**Planning Department  
Transportation Development Services**

May 21, 2015

**Re: State of New Mexico Environment Department-Springer Building  
121 Tijeras Ave. NE  
Traffic Circulation Layout  
Engineer's/Architect's Stamp dated 4-20-15 (K14-D036)**

1 TEMPORARY PARKING IMPROVEMENTS 1/16" = 1'-0"

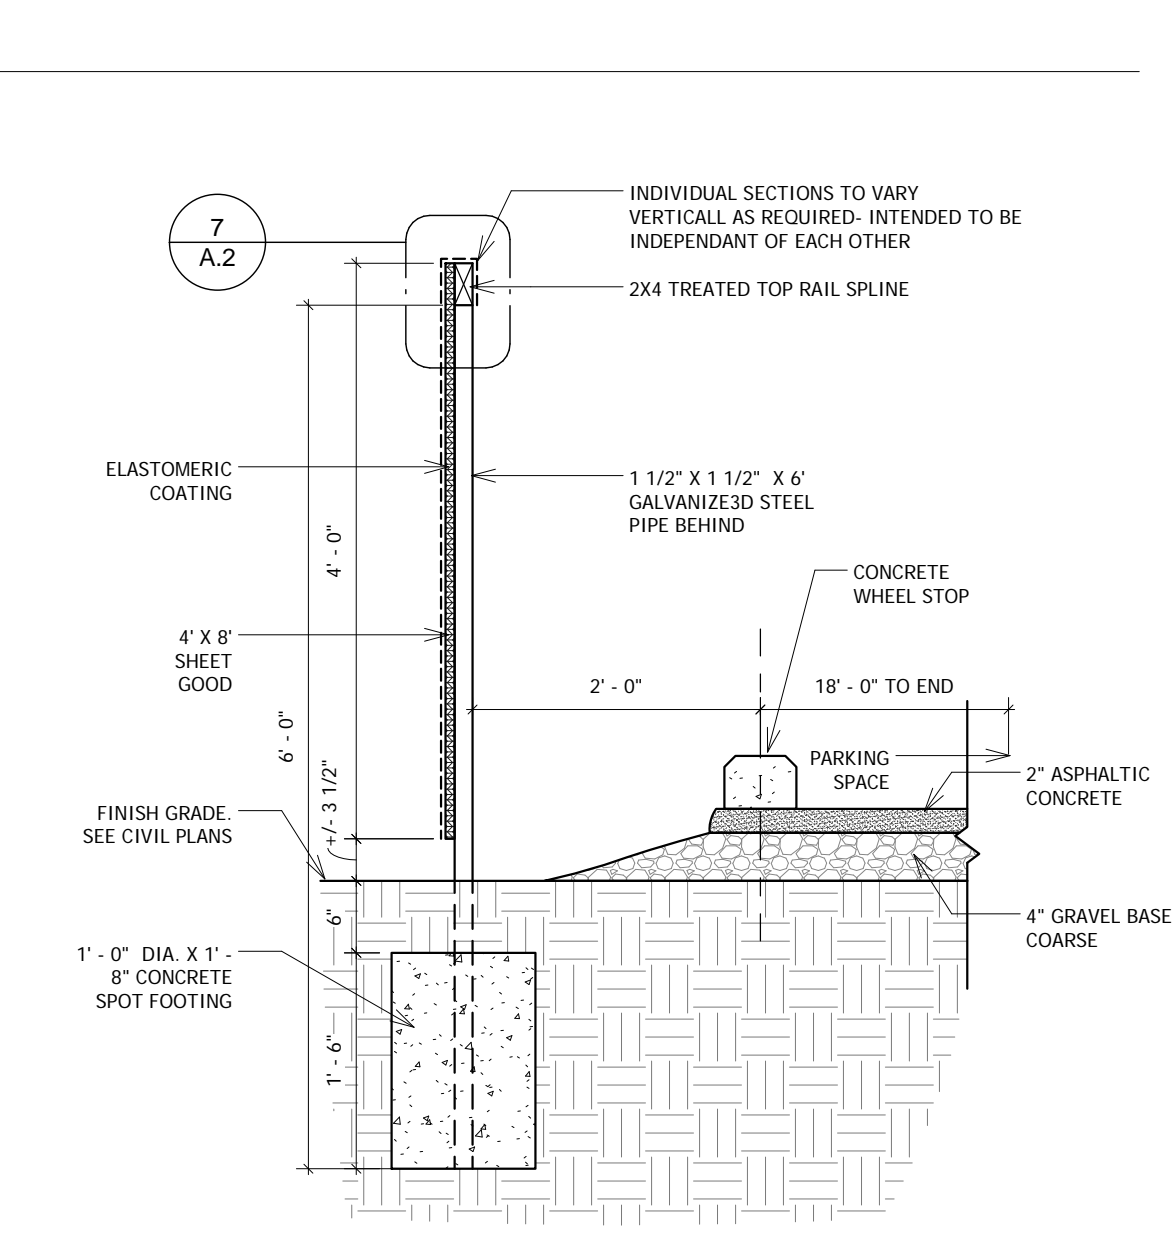
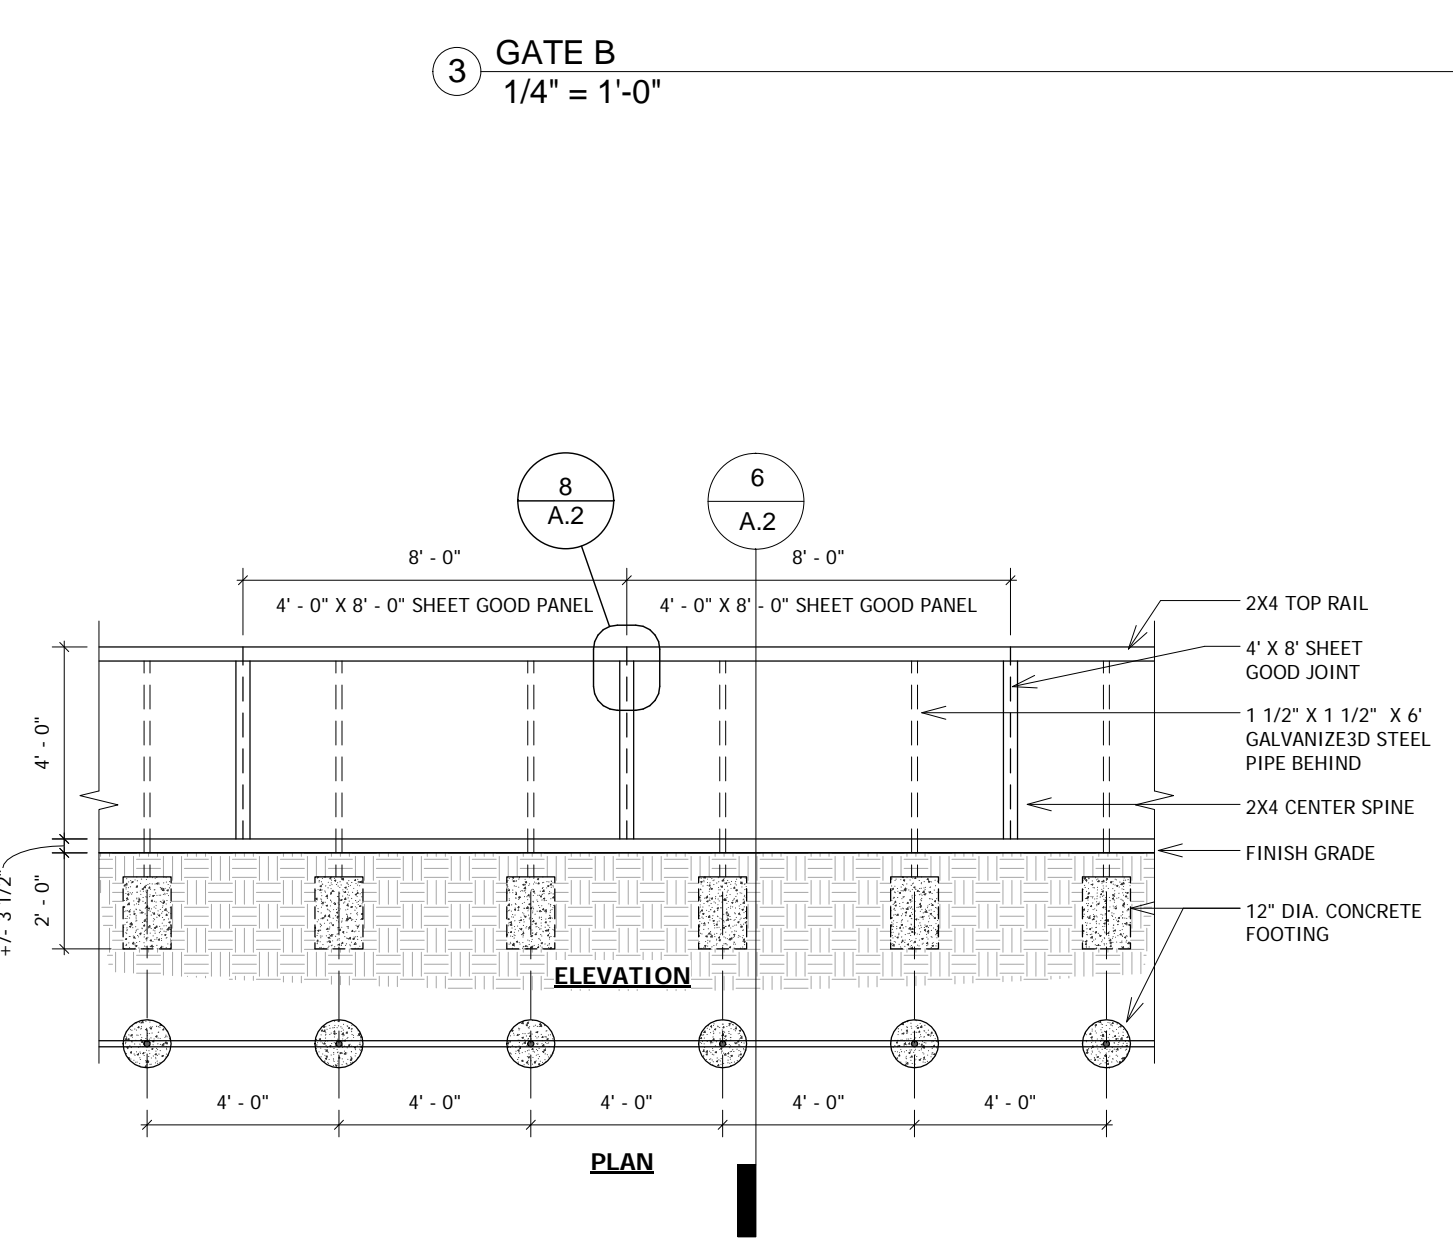
1. Please show a vicinity map showing the location of the development in relation to streets and well known landmarks.
2. Label new lot as "Overflow Parking".

3. Clarify the extents of the current phase. Please label existing buildings.
4. Please clarify the use of temporary parking. Is it be used just during construction?

5. Please identify all existing buildings, doors, structures, sidewalks, curbs, drive pads, walls and anything that influences the parking and circulation on the site.

6. Identify all existing access easements and rights of way with dimensions.
7. Identify the right of way width, medians, curb cuts, and street widths on Tijeras Ave., Dr. Martin Luther King Jr.Ave., and Commercial St.

8. The lot must be graded and surfaced with blacktop or equal: Two inches of asphalt concrete on a prime coat over a four inch compacted subgrade, or a surface of equal or superior performance characteristics. If street curbs and gutters exist adjacent to the parking lot property on a side where lot egress is allowed, the surfacing shall be blacktop for the width of the egress drive(s) and shall extend inward from the property line a minimum of 25 feet along all normal lines of egress traffic flow from the lot. All paving shall be maintained level and serviceable (i.e. no potholes). The City Engineer will have to approve a grading and drainage plan before the asphalt can be installed.

9. For parking lots of 20 or fewer spaces: A layer at least two inches thick of gravel sized from 3/8 minimum to one inch maximum diameter, at least ½ inch of which shall be maintained on the surface; gravel shall be kept off the right-of-way.

11. The lot shall have barriers which prevent vehicles from extending over the sidewalk or abutting lots, or beyond the sides of a parking structure. The plans do already address providing concrete vehicular wheel stops.

12. Please list the width and length for all existing and proposed parking spaces. Please clearly detail how each parking space is to be marked and if there will be curb stop or car parking bumpers installed in each parking space. The minimum parking space width is 8.5 ft.

13. The ADA van accessible sign must have the required language per 66-7-352.4C NMSA 1978 **"Violators Are Subject to a Fine and/or Towing."** Please show a detail of the existing ADA signs.

14. The ADA access aisle shall have the words **"NO PARKING"** in capital letters, each of which shall be at least one foot high and at least two inches wide, placed at the rear of the parking space so as to be close to where an adjacent vehicle's rear tire would be placed. (66-1-4.1.B NMSA 1978)

15. Show all drive aisle widths and radii.
16. List radii for all curves shown; for passenger vehicles, the minimum end island radius is 15 feet. Landscape island radius for delivery trucks, fire trucks, etc. is 25 feet or larger

17. Per the DPM, a 6 ft. wide ADA accessible pedestrian pathway is required from the public sidewalk to the building entrances. Please clearly show this pathway and provide details from the proposed temporary parking.

18. Per the DPM, a 6 ft. wide ADA accessible pedestrian pathway is required from the HC parking stall access aisles to the building entrances. Please clearly show the ADA pedestrian pathway from the existing and proposed parking to the building entrance.

19. Provide a min 6" or max 8" high concrete barrier curb or other acceptable barrier between landscaping and parking areas and/or drive aisles.
20. Please provide a sight distance exhibit for entrance off of Broadway Blvd. (see the *Development Process Manual, Chapter 23, Section 3, Part D.5 Intersection Sight Distance*).

21. Please add the following note to the clear sight triangle: "Landscaping and signage will not interfere with clear sight requirements. Therefore, signs, walls, trees, and shrubbery between 3 and 8 feet tall (as measured from the gutter pan) will not be acceptable in this area."
22. Please specify the City Standard Drawing Number when applicable.
23. Work within the public right of way requires a work order with DRC approved plans.
24. See Chapter 23, Section 6 of the City of Albuquerque *Development Process Manual*, for appropriate drive pad widths.
25. Please include two copies of the traffic circulation layout at the next submittal.
